KITTITAS COUNTY DEPARTMENT OF PUBLIC WORKS

DATE: October 2, 2018

RE: Wenger Short Plat – Final Plat (SP-07-00007)

KITTITAS COUNTY		WASHINGTON	
DWN BY	DATE	JOB NO.	
S.W./G.W.	08/2018	06305	
CHKD BY	SCALE	SHEET	
M.K.K./S.W.	N/A	2 OF 3

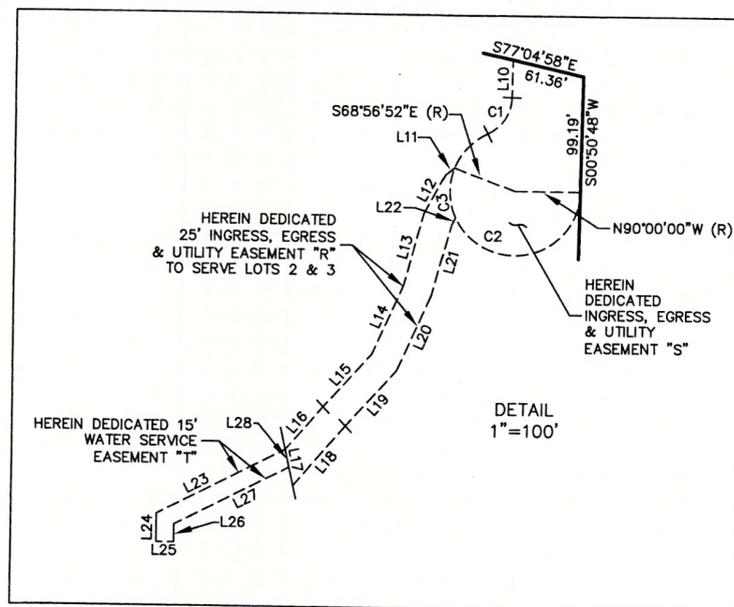
1. Preliminary condition of approval 7(d)(v) requires the access to parcel 616536 be shown on the final plat. That condition is not met on the final plat that I have been provided for review. Please instruct that the parcel number (616536) be added to note 14 or shown on the face of the plat.
